Response to 6/2021/3422/MAJ – Salisbury Square

Comments from Willow House Management (Hatfield) Ltd 18a-e Salisbury Square, AL9 5BE

TITLE: REFUSE SWEEP PATH ANALYSIS

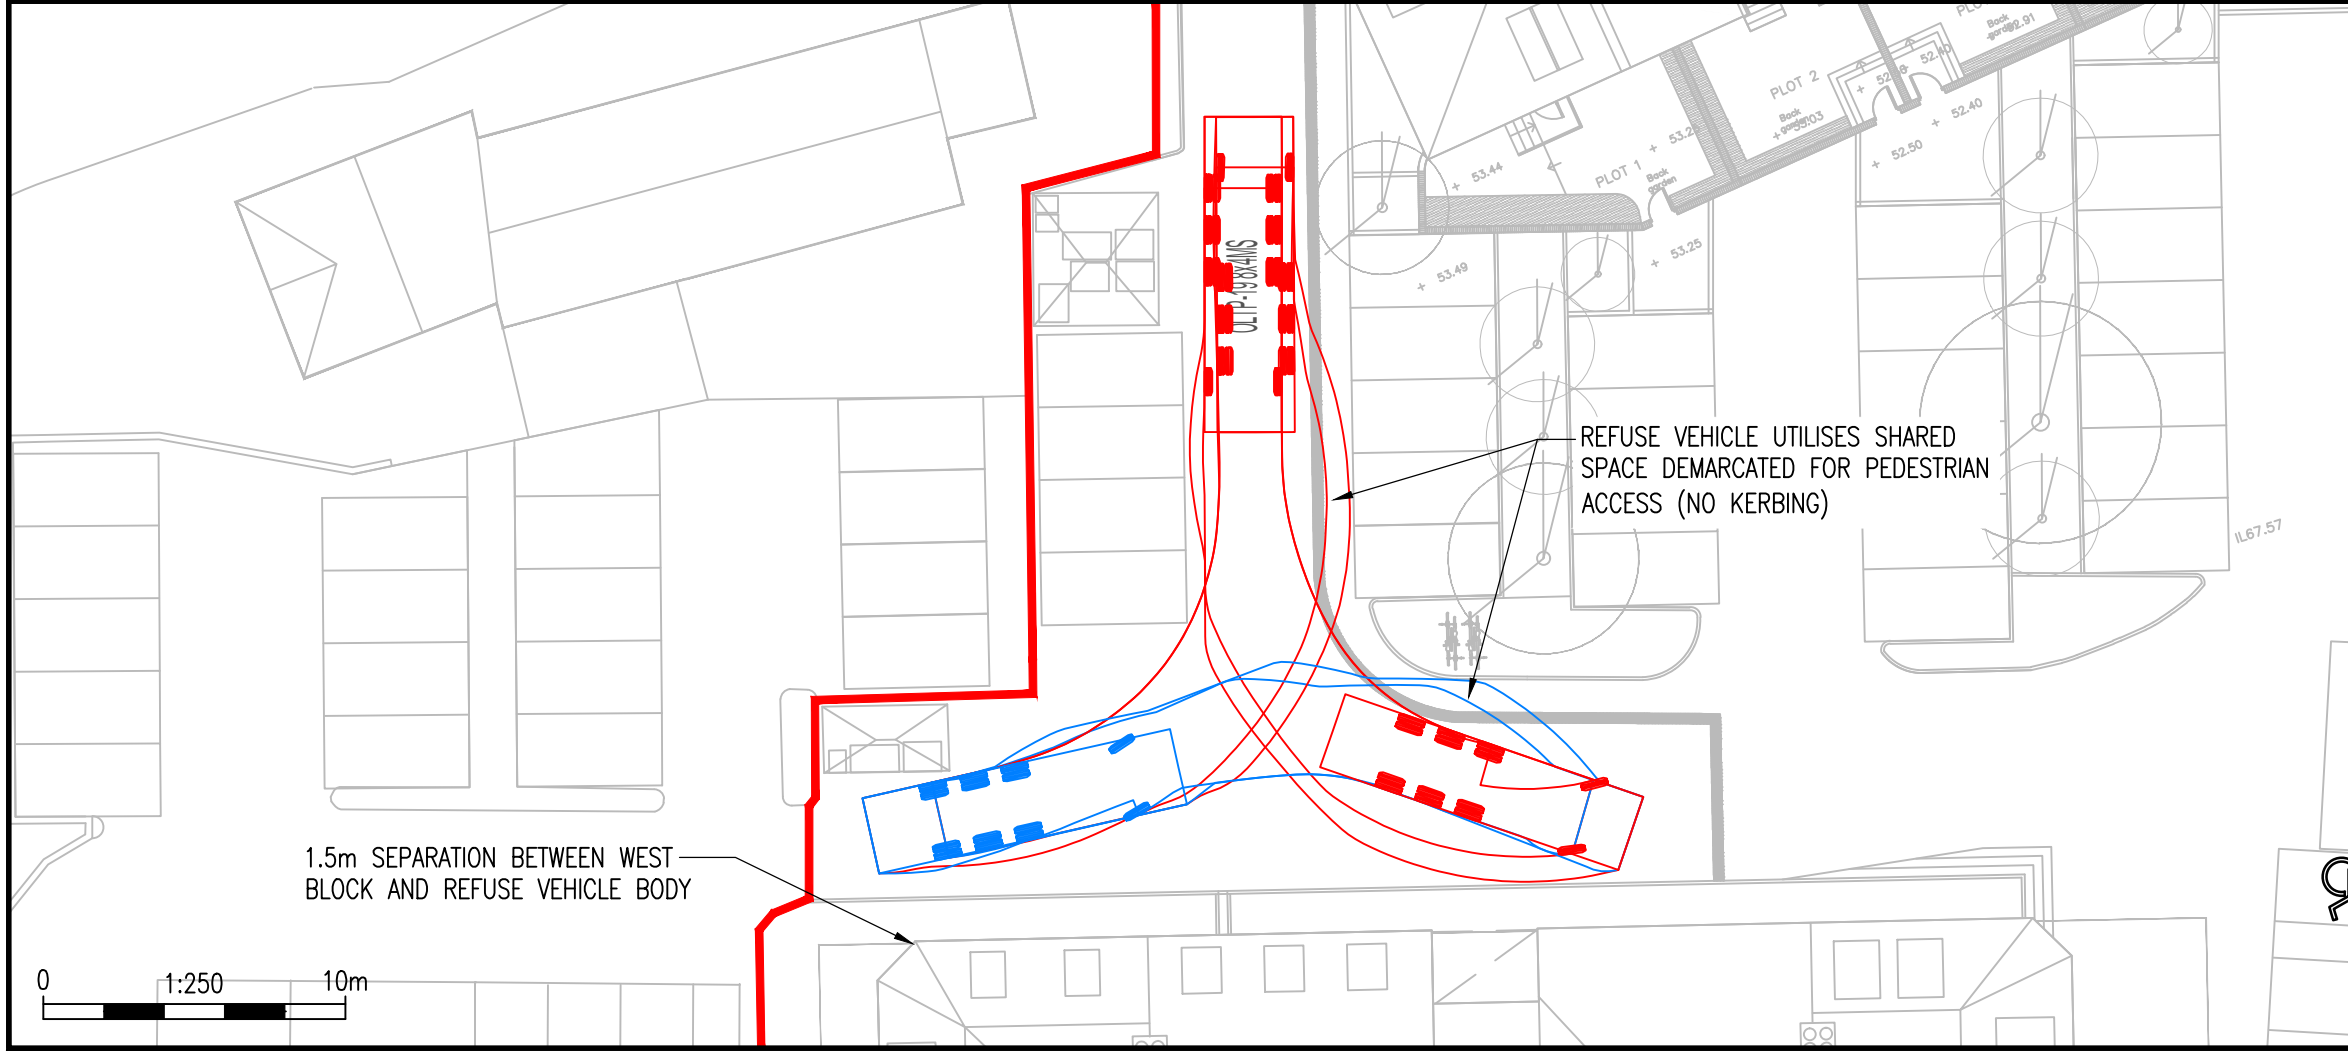
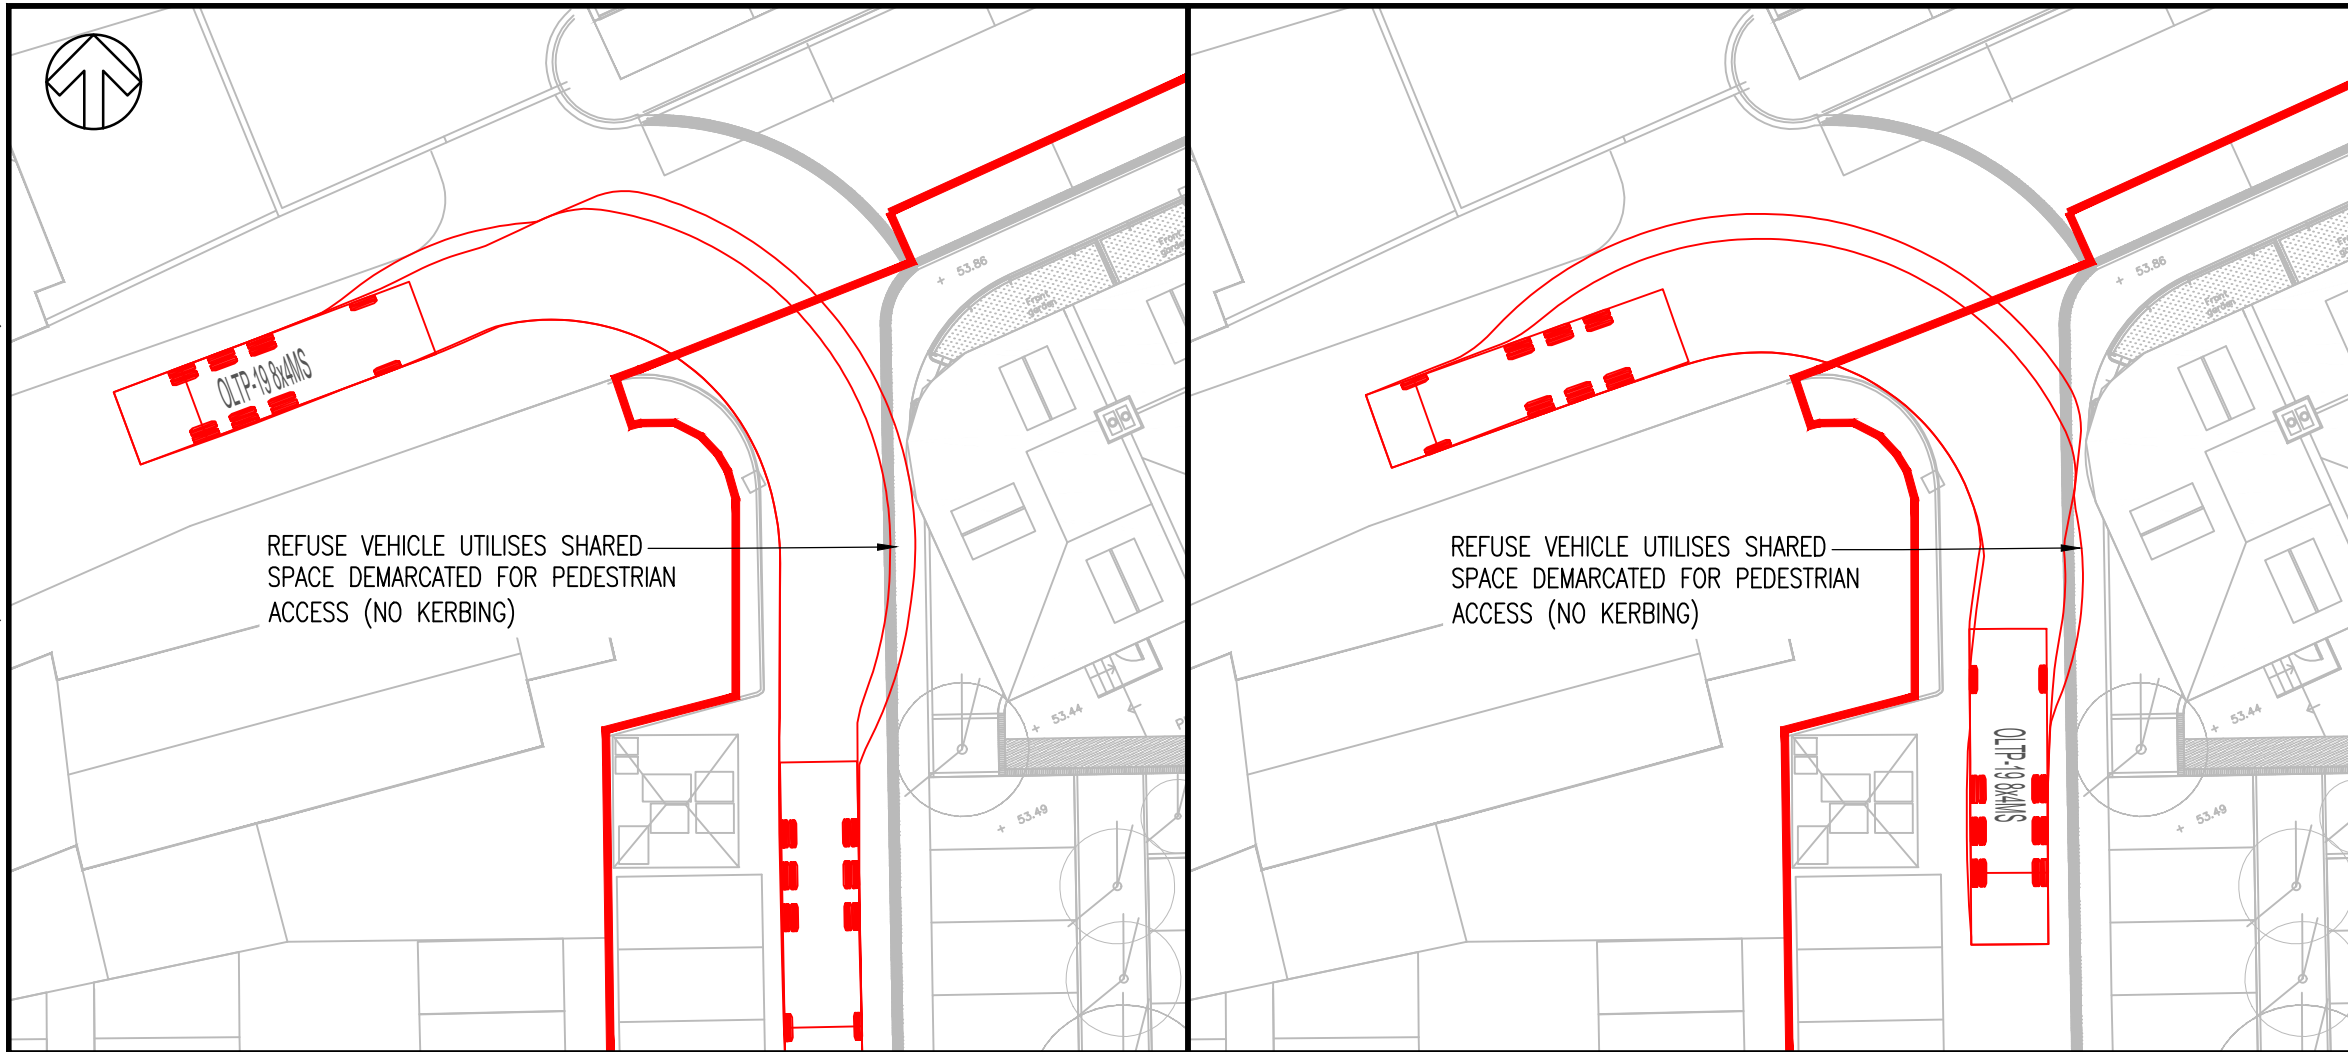
5. No through Road. We note that the option of a through road from the Eight Bells to Salisbury Square has been ruled out. We welcome this, and ask that the potential turning difficulties in the area outside Willow House Flat A are properly addressed.
6. There is no information on plans for the various trees on the site, and there does not appear yet to be a landscape / planting plan. Recent developments do not inspire confidence that the developer is interested in green landscaping, and a plan should be required including maintenance responsibility.
